Our reference: P-603321-COL3
Contact: Sandra Fagan
Telephone: (02) 4732 7992

18 January 2024

Council Response to EIS Report - SSD-60513208 – Stage 4 – Warehouse 8 – Aspect Industrial Estate at 804–882 Mamre Road, Kemps Creek, NSW, 2178.

Figure 1: Site Plan

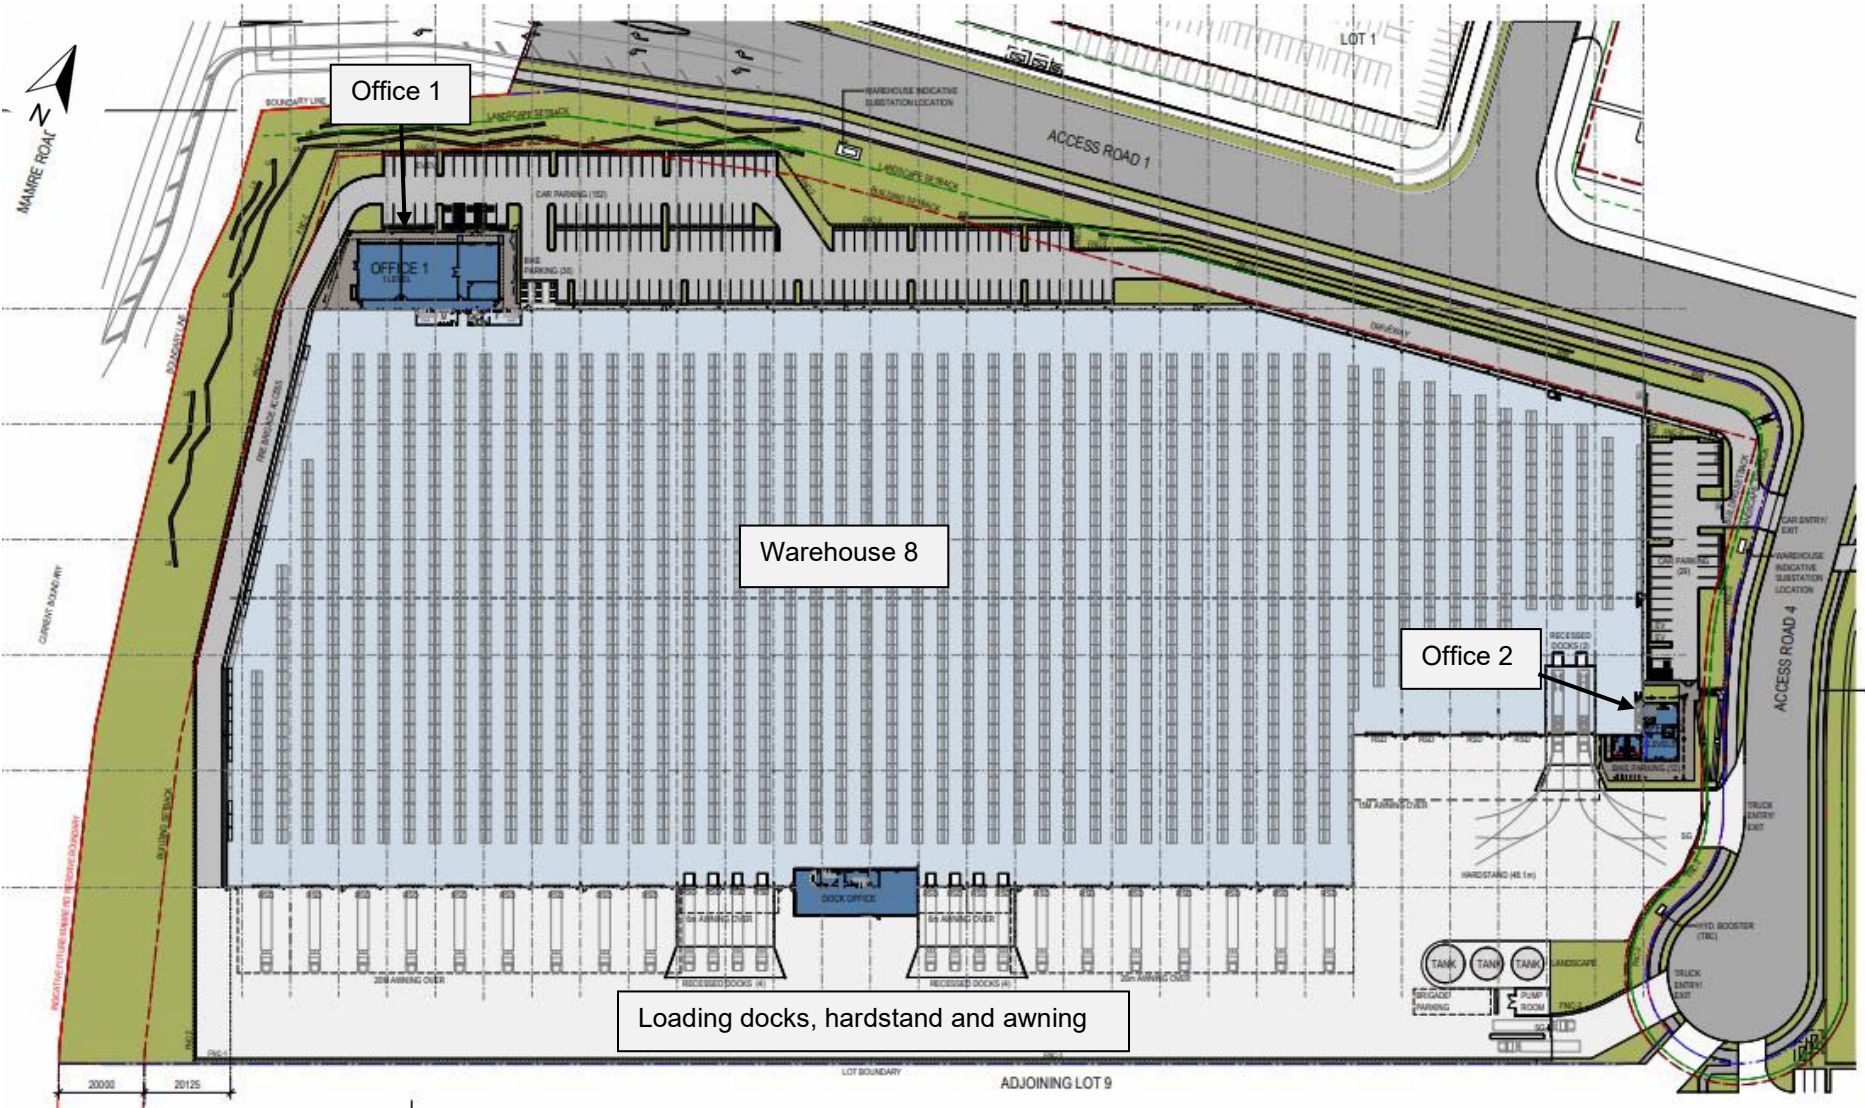
- e) DPHI should consider if any additional vegetation is required (in other areas) to compensate for the proposed increase in hardstand area on the southern side of the building and the new truck driveway. DPHI could consider whether the six proposed car parking spaces above the DCP minimum parking rate should be converted to additional landscaping instead of parking.

- g) DPHI should ensure that the proposed ancillary use of warehouse 8A (for the purpose of a workshop and training area associated with the car parts to be stored within the warehouse) is either permitted and/or clearly remain an incidental use. The proposed floor plan for warehouse 8A shows an area for the workshop/training space that appears to occupy about one-quarter of the warehouse footprint.

- h) DPHI should consider whether there are any additional proposed retaining walls fronting roads, given that the proposal includes raising the pad level of warehouse 8 by approximately 0.57 metres. Any retaining walls should be set back from road frontages and designed in accordance with the DCP (with tiers when required and planter boxes for vegetation). The EIS refers to retaining walls along the northern boundary of Lot 8, adjacent to access road 1.
- i) DPHI should consider conditions that require further assessment and endorsement of any future exhaust vents that are required for the warehouse use (as referenced on page 78 of the EIS) particularly given that the number and height of such vents is not known at this time.

- a. It is recommended that the retaining wall/s, including the proposed landscape sandstone walls, be at least 2m set back from any public land/road reserve, in accordance with Mamre Road DCP. The plans should be updated to reflect this.

- i. the vehicular access must be located a minimum of 6m from the tangent point (TP) of the curve return and must be reflected on the detailed plan.
- ii. the accesses must provide sufficient clearance from any infrastructure such as kerb/pram ramp, stormwater side entry pit, and any street trees. All infrastructure must be shown on the plans with their separation from the proposed accesses/laybacks.
- iii. at least the first 6m of access driveway into the car park must have no more than a 1 in 20 (5%) grade in accordance with AS 2890.1. Although the relocated access will service user class 4, the Dwg. No 2810- Section 3 by AT&L indicates higher than 5% grade for the first 6m of the access driveway (as shown on the snippet below) which should be amended to comply with AS 2890.1.

- i. the swept paths indicate that the new heavy vehicle access for tenancy 8B is only suitable for up to 20m articulated vehicles (AVs).
- ii. the swept paths indicate heavy rigid vehicles (HRVs) encroach the centreline of Road 4 while exiting Lot 8 using the relocated access from the carpark. This is not acceptable. Subject to satisfactory swept path diagrams, this vehicular access may only be suitable for B85, B99 and SRVs.
